Application H11-0399-17
Location Land adjacent: 44 Bridge Road Long Sutton Spalding PE12 9EF
Proposal Proposed residential development

Name Glen Chapman
Address Environmental Services South Holland District Council

Date Submitted 08-05-17
For/Against Comments

Job Title Proposed Residential Development Bridge Road, Long Sutton for: I M N Properties Ltd	Date March 2017	Scale As Shown Sheet Size A1
	Drawing Title Outline Planning Drawing	Job No. SE-728 Dwg No. 02
		Drawn by G.E Revision

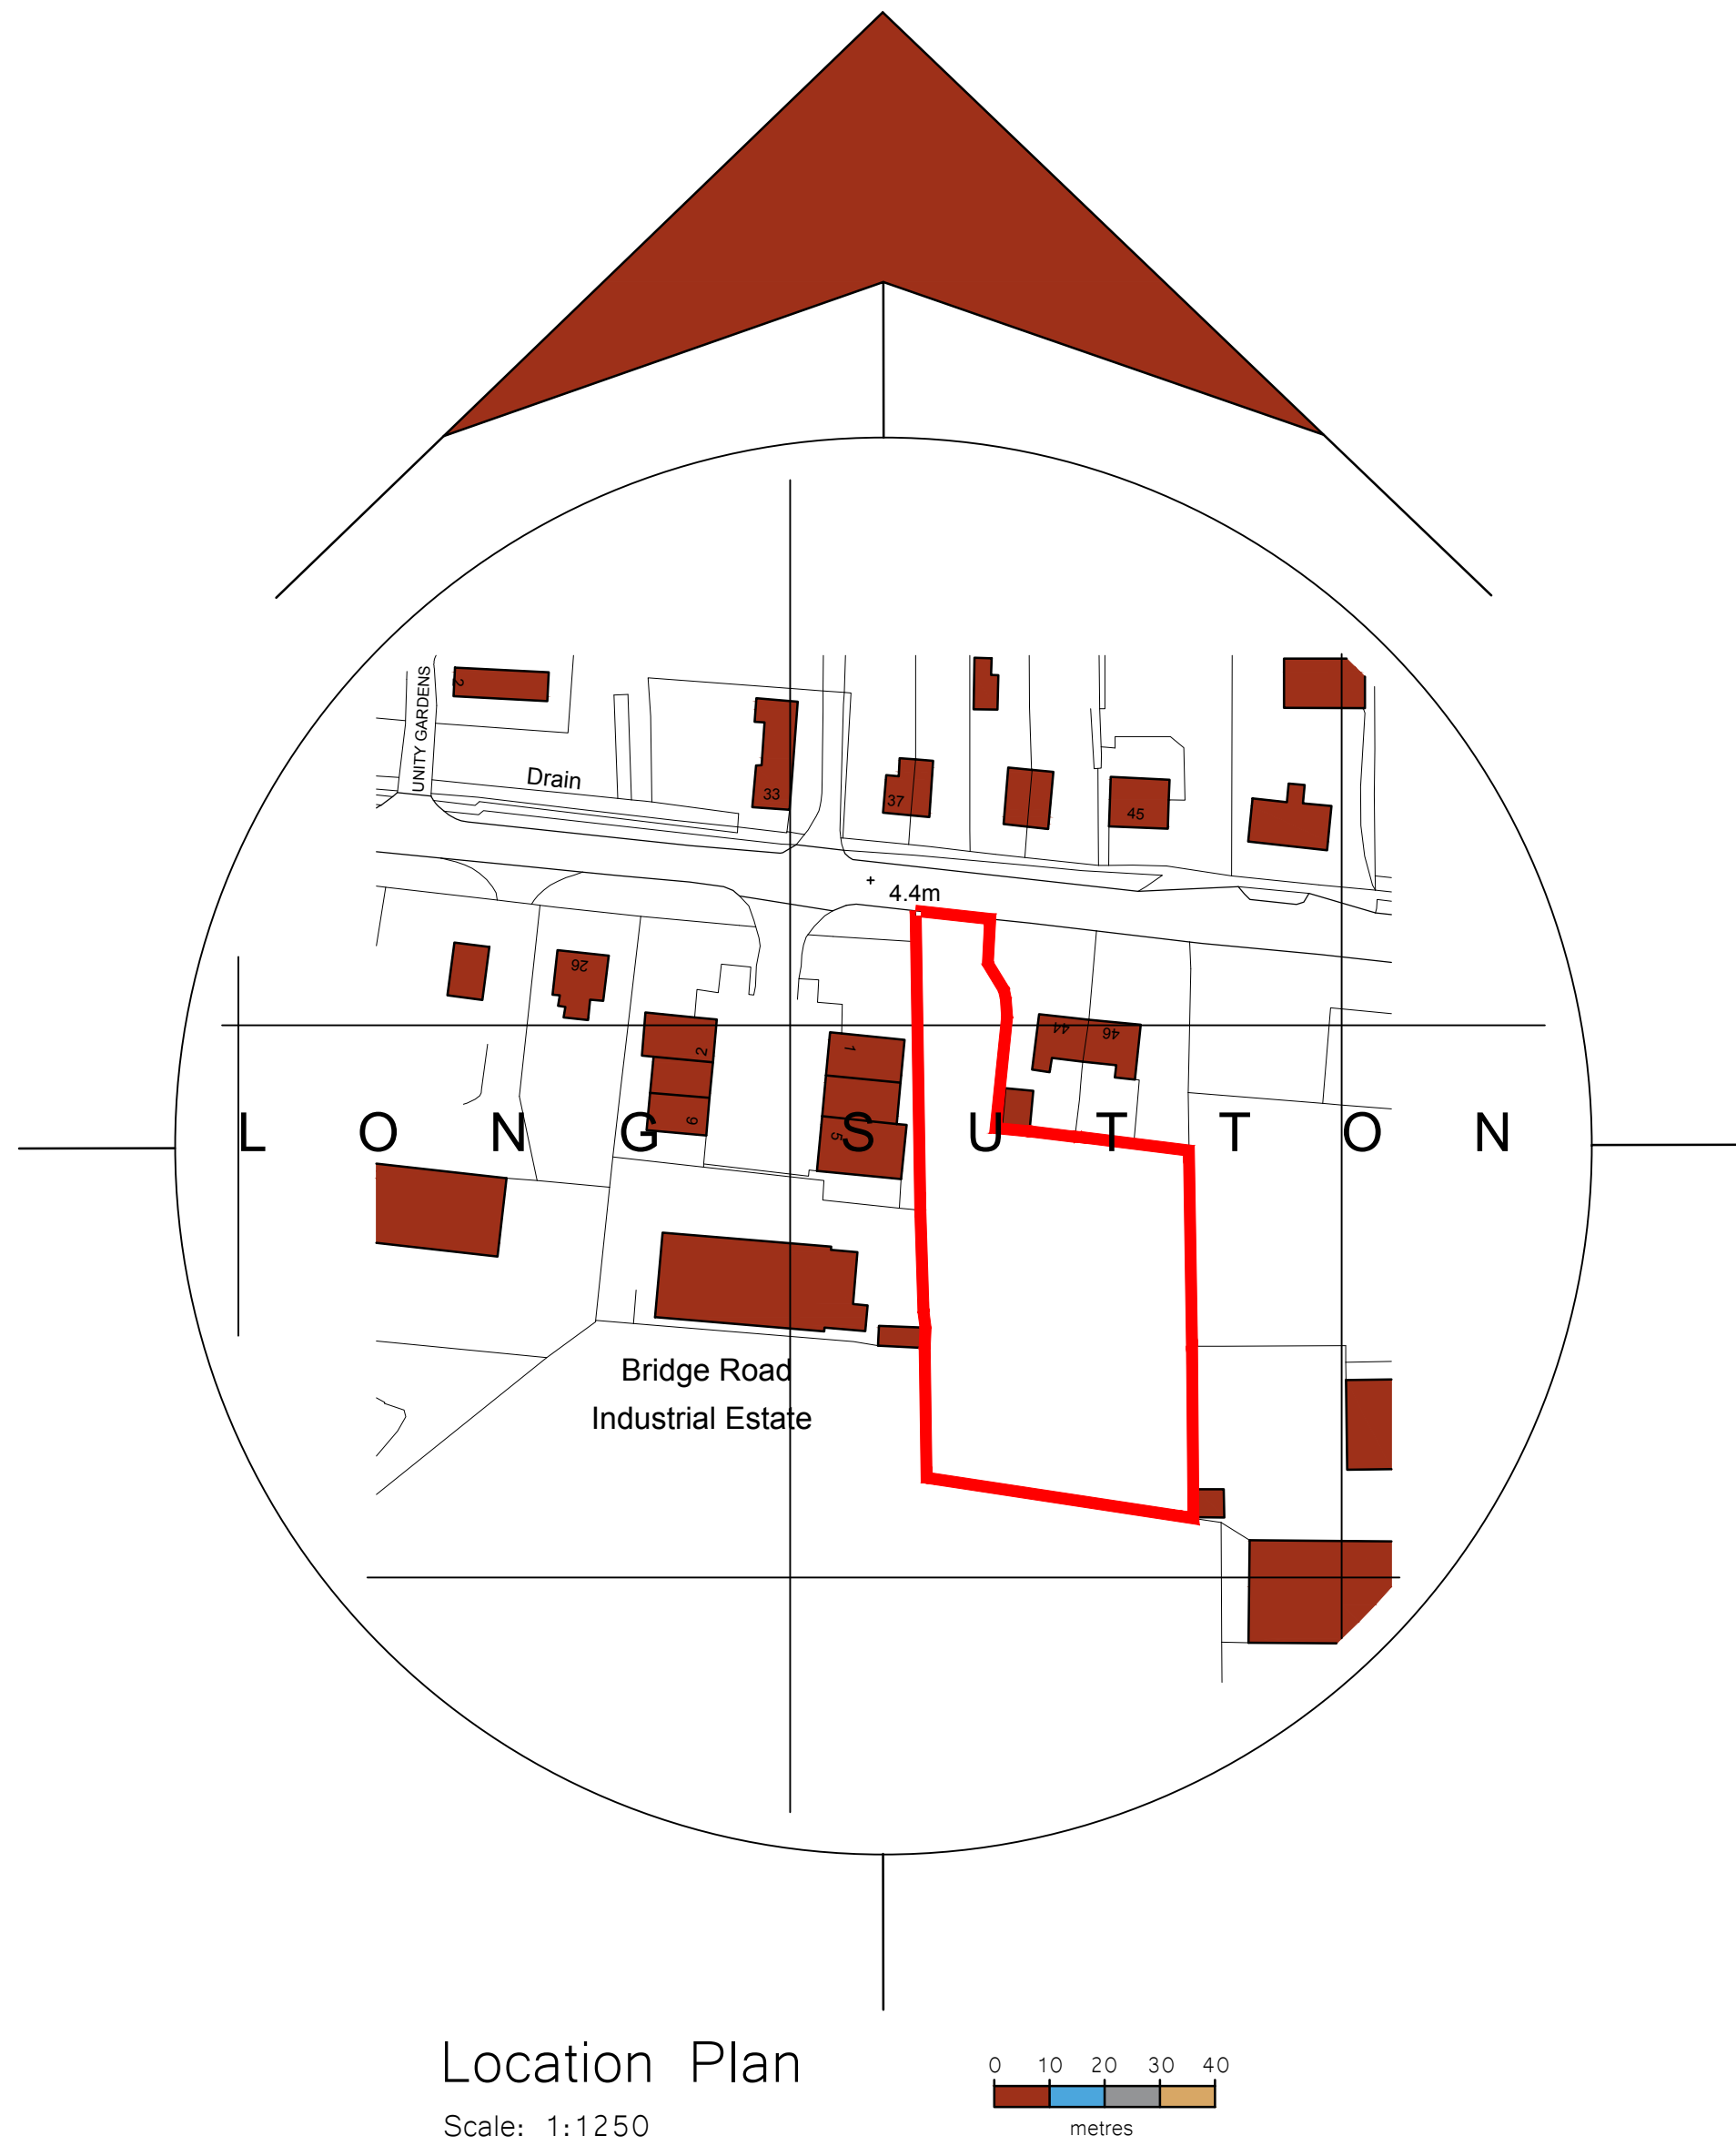
Access roadways to all residential properties should be constructed to an adoptable standard under an agreement with Lincolnshire County Council so that they will become public highways. This will enable refuse/recycling collections to be carried out from outside individual properties without the need for communal collection points at the point where private driveways adjoin public highways.

If not utilised correctly communal collection points become areas of dispute for residents of adjacent properties.

Should it be agreed that communal collection points will form part of this development the position of those collection points should be made clear to the potential occupiers of the properties nearby. This should not just be to the properties that will need to use the collection points but also the ones who will have them outside their properties.
